Review Response

Project Name: Helms Retaining Wall

Response To: Helms Ret Wall (SHL22-026)

This letter is in response to the corrections for shoreline exemption SHL22-026. Below are our responses to the questions/comments from 1/12/23.

PROPOSED CONDITIONS

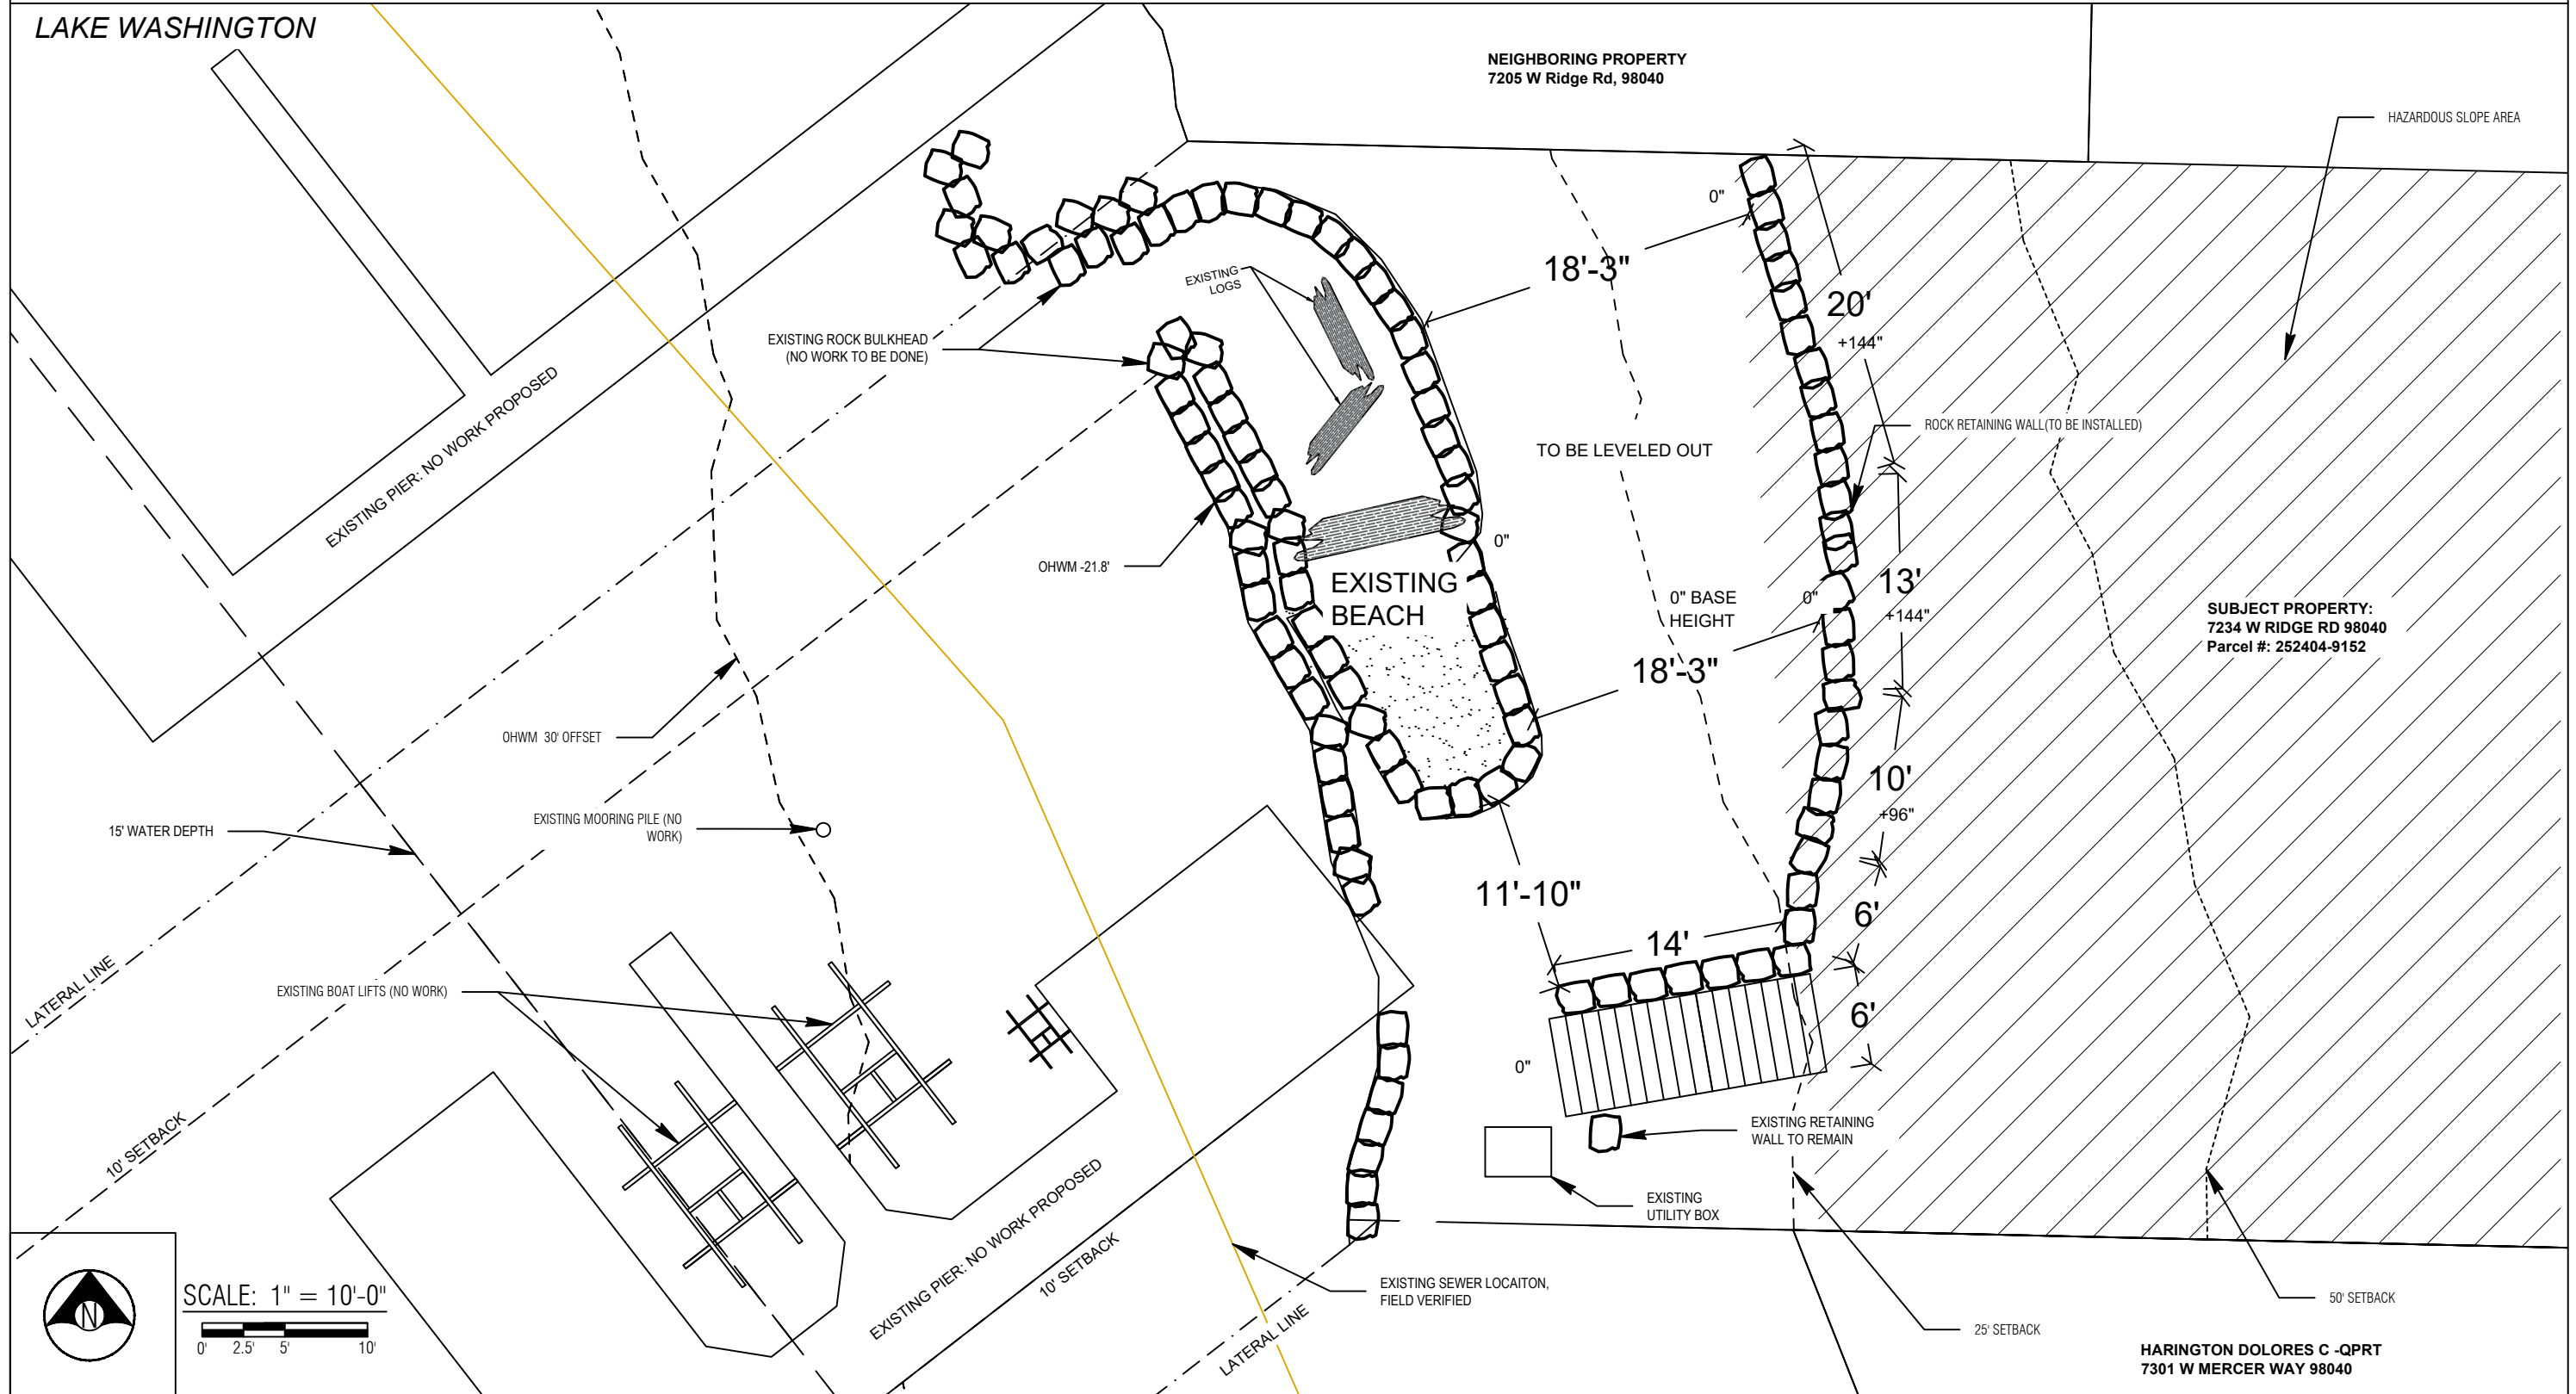
6. Bulkheads shall be located generally parallel to the natural shoreline. No filling may be allowed waterward of the ordinary high water mark, unless there has been severe and unusual erosion within two years immediately preceding the application for the bulkhead. In this event the city may allow the placement of the bulkhead to recover the dry land area lost by erosion.

No fill will be placed waterward of OHWM, and wall will be located approximately parallel to existing shoreline.

SHEET
5.0

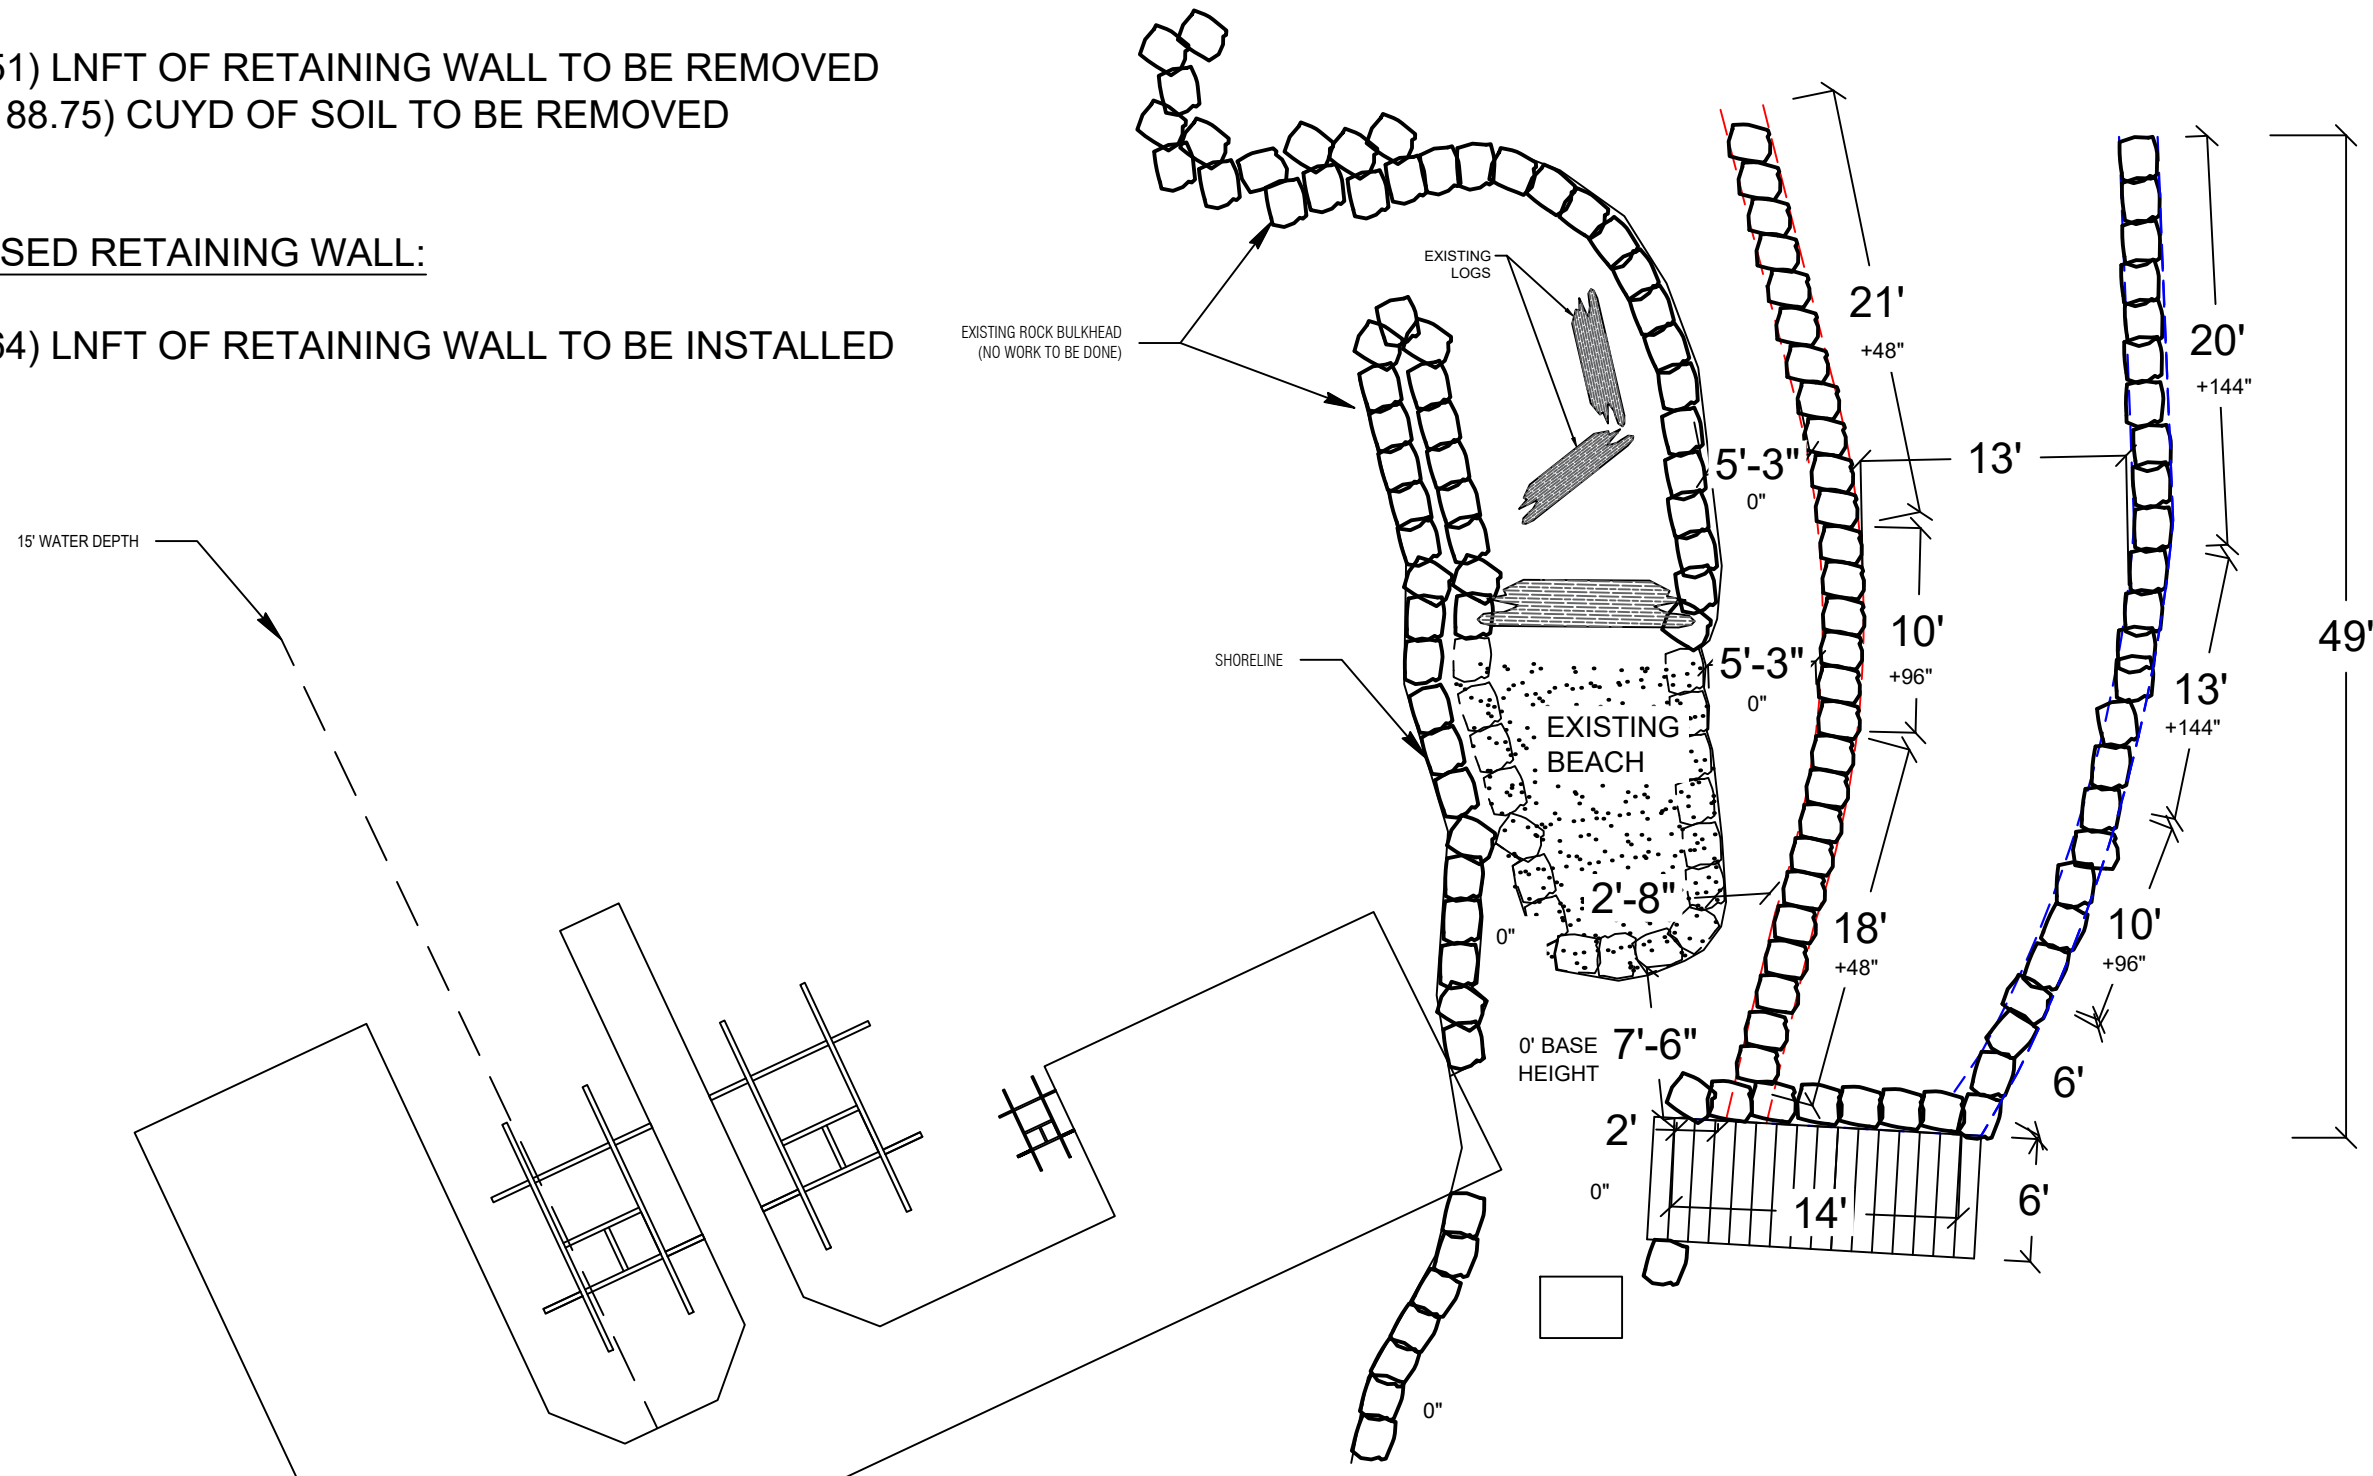
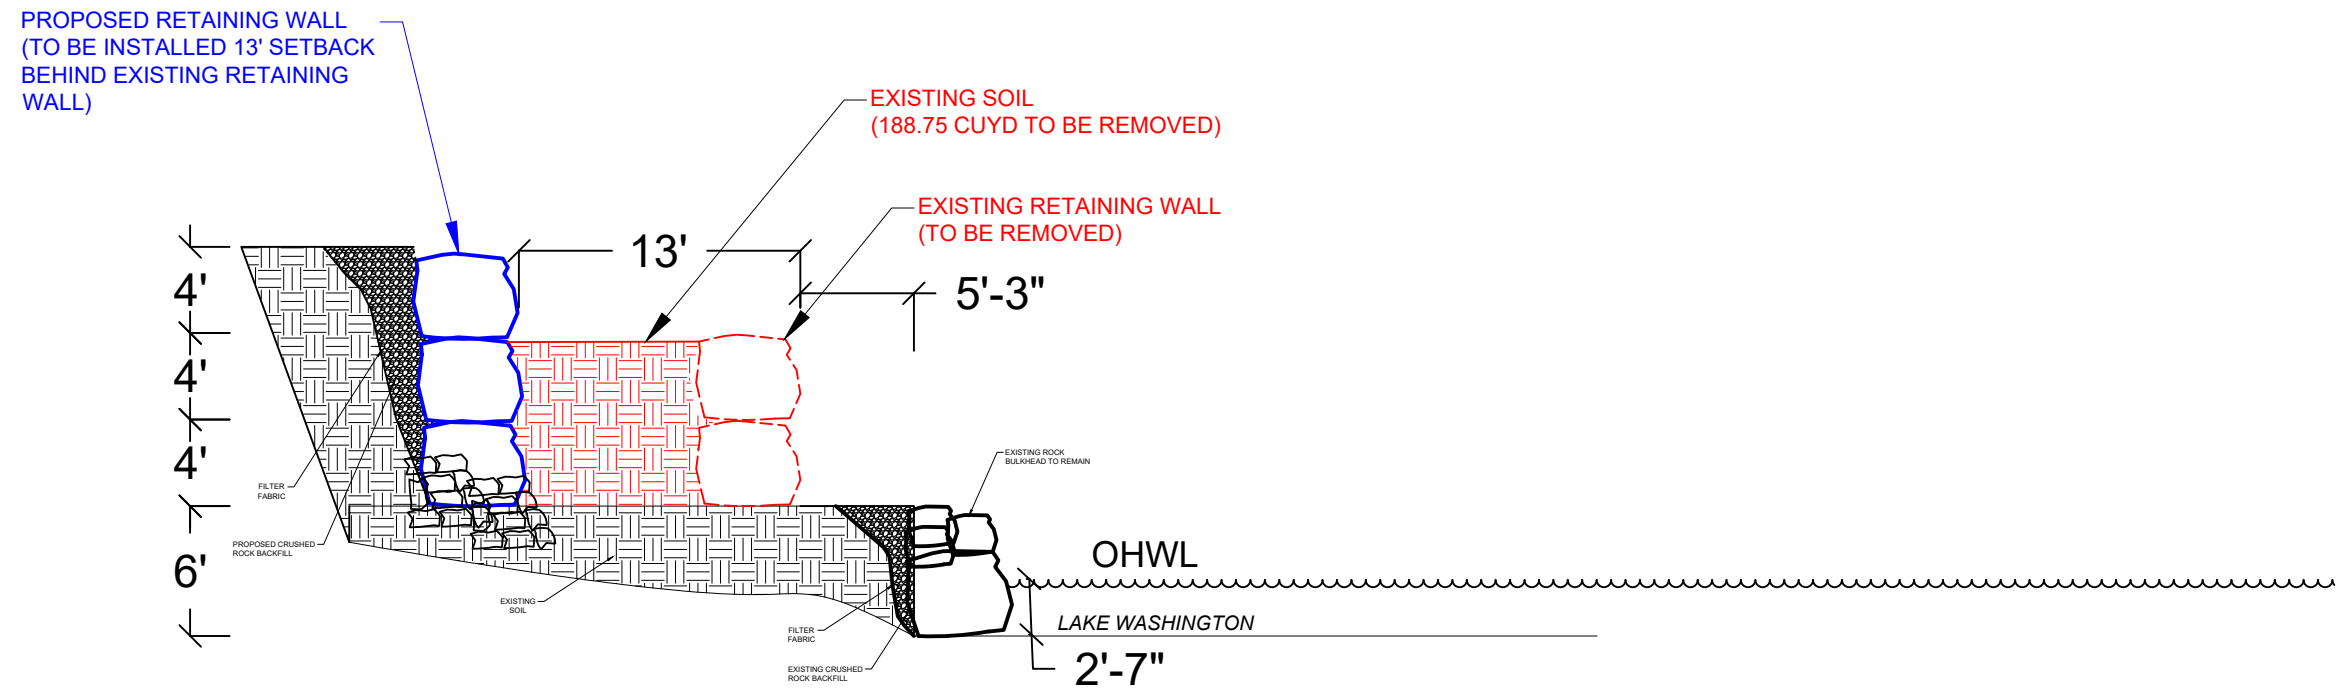
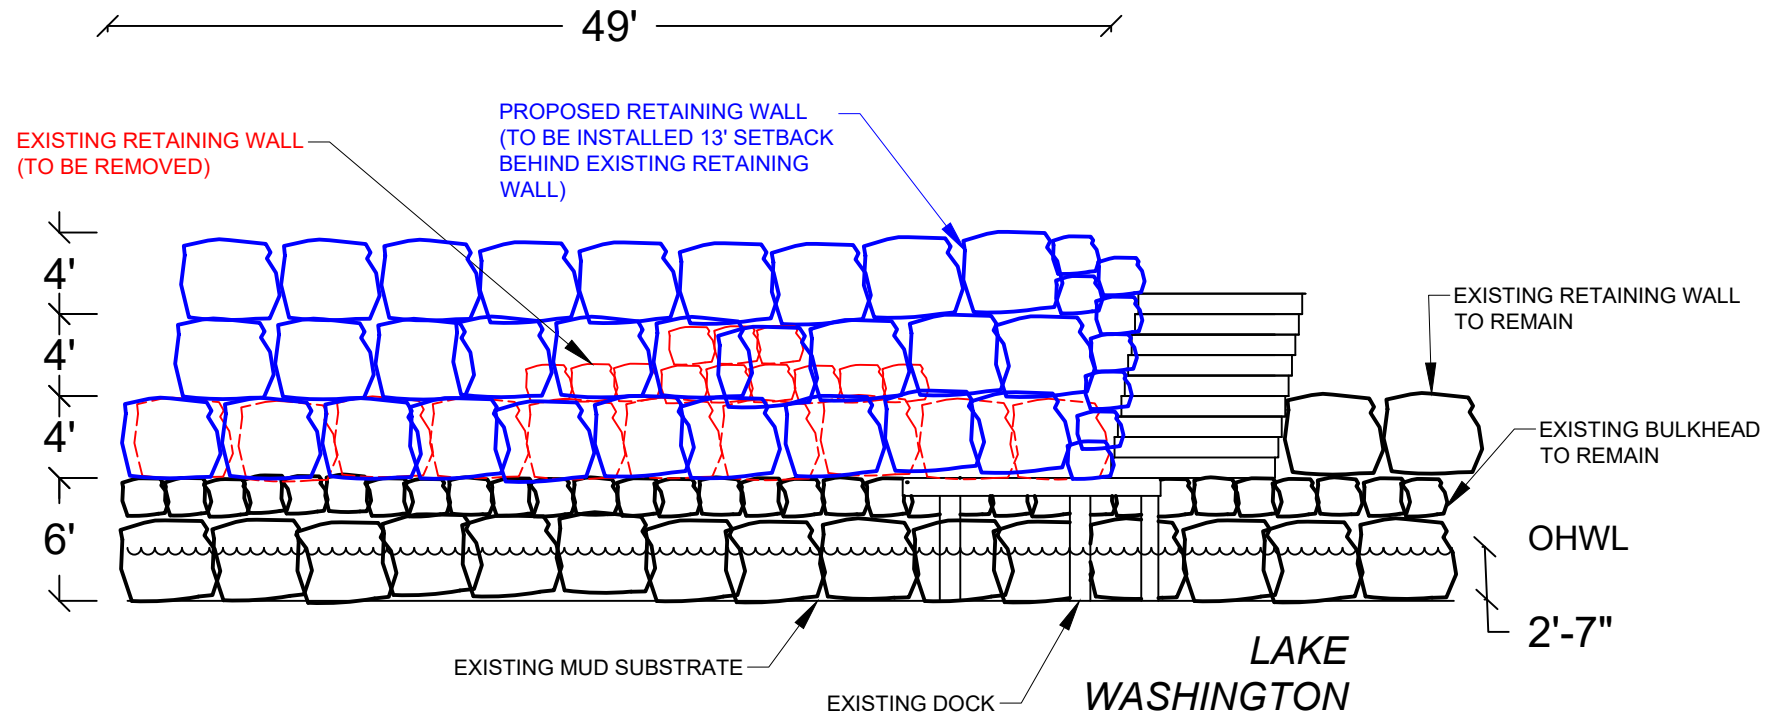
The proposed retaining wall is an increase in size of existing shoreline stabilization measures therefore considered a new structure and not a replacement of the existing structure.

Understood. See analysis above for how project meets code requirements for new shoreline stabilization.
